Peer Review of Flood Modelling undertaken for the Macintyre River Floodplain

Inland Rail Project
North Star to Queensland Border (NS2B)

Goondiwindi Regional Council

1283-02-D1, 27 November 2020

Figure B2-C:
1976 Calibration Event
Peak Depths and Water Surface Levels

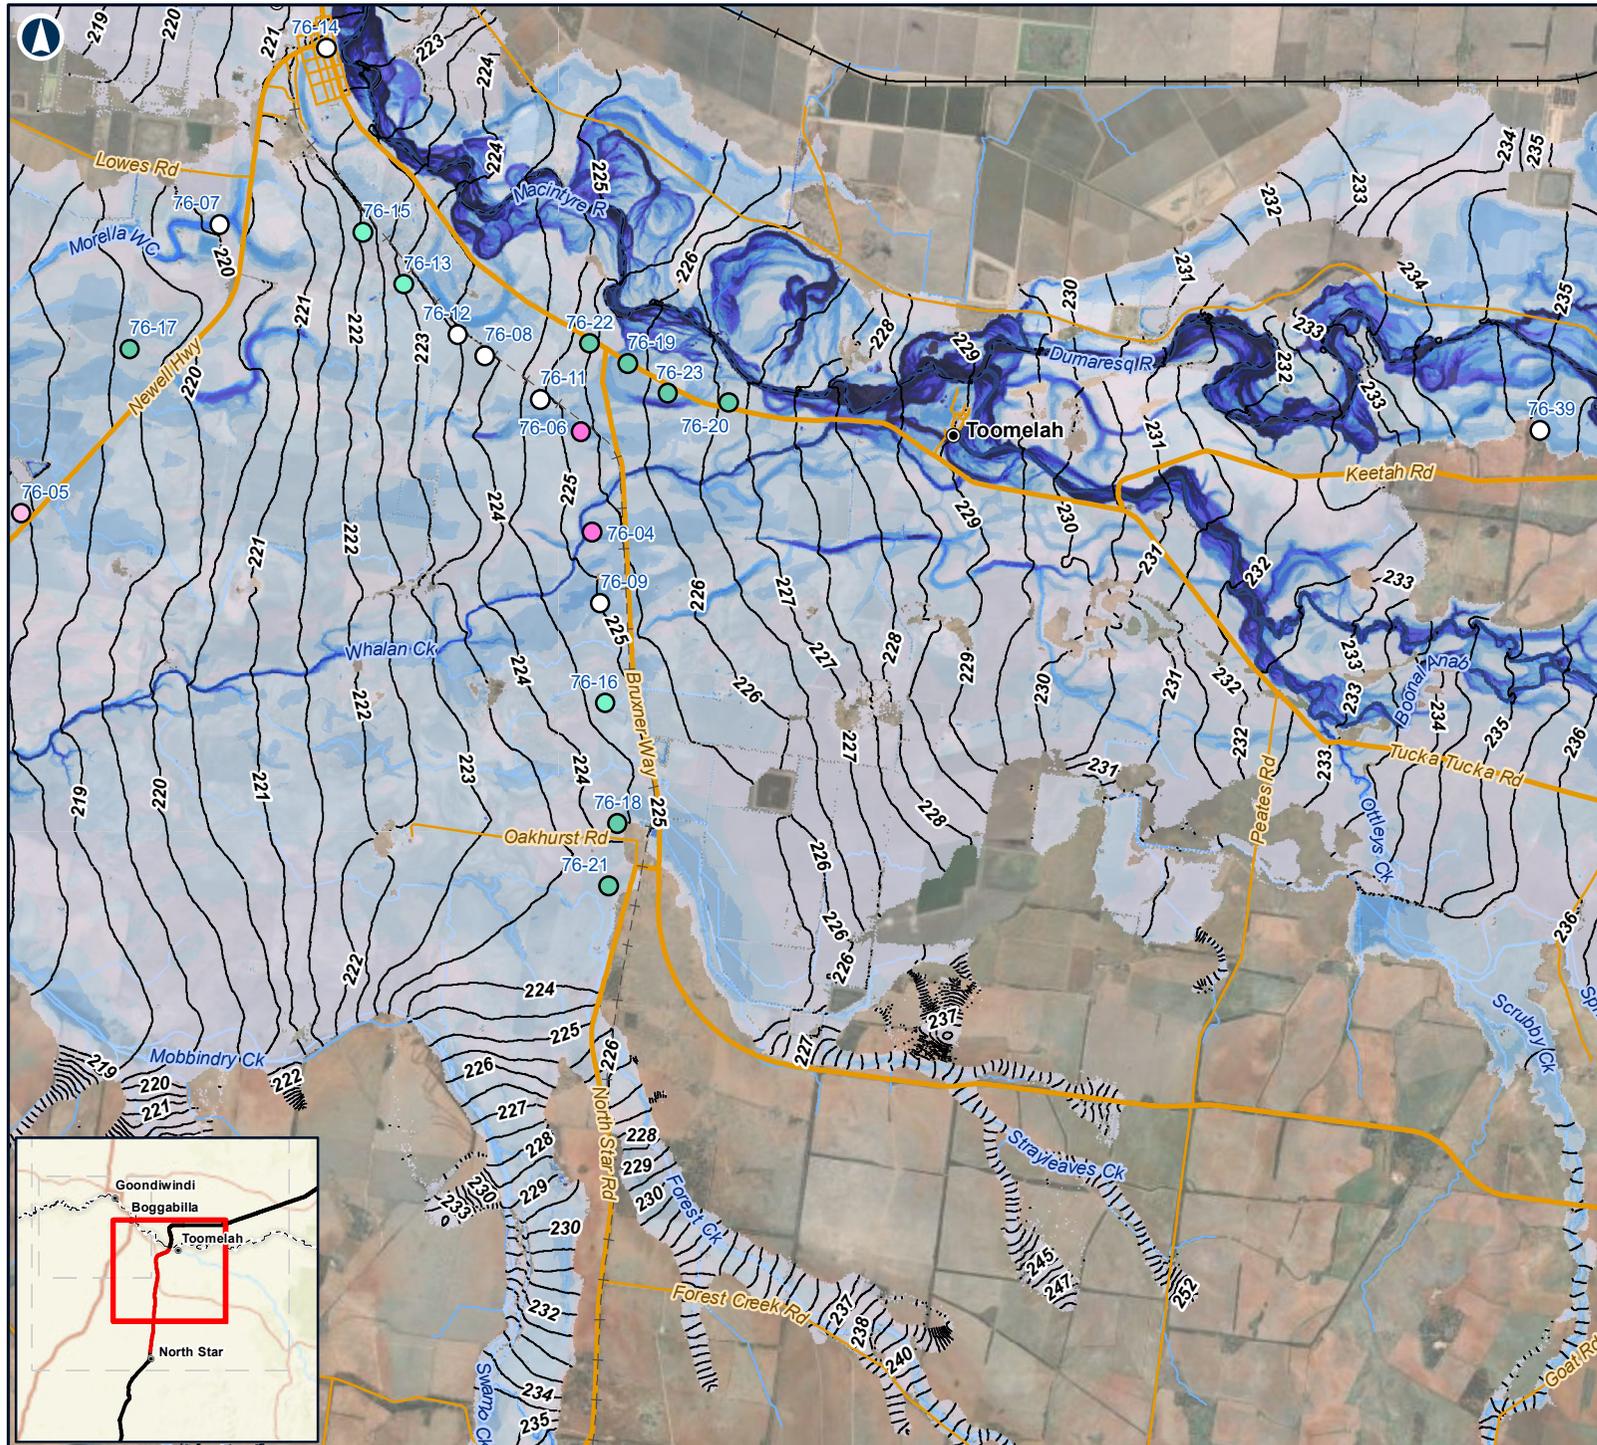
It appears that the older topographic datasets have been used with some adjustments as seen fit for the historical (1976, 1996 and 2011) event hydraulic model calibration.

Anecdotal flood data collected from previous studies, DPIE, Councils and land holders has been used for model calibration. These data, which have varying levels of accuracy and reliability, have comprised mainly aerial photographs, landholder photographs and surveyed debris mark levels.
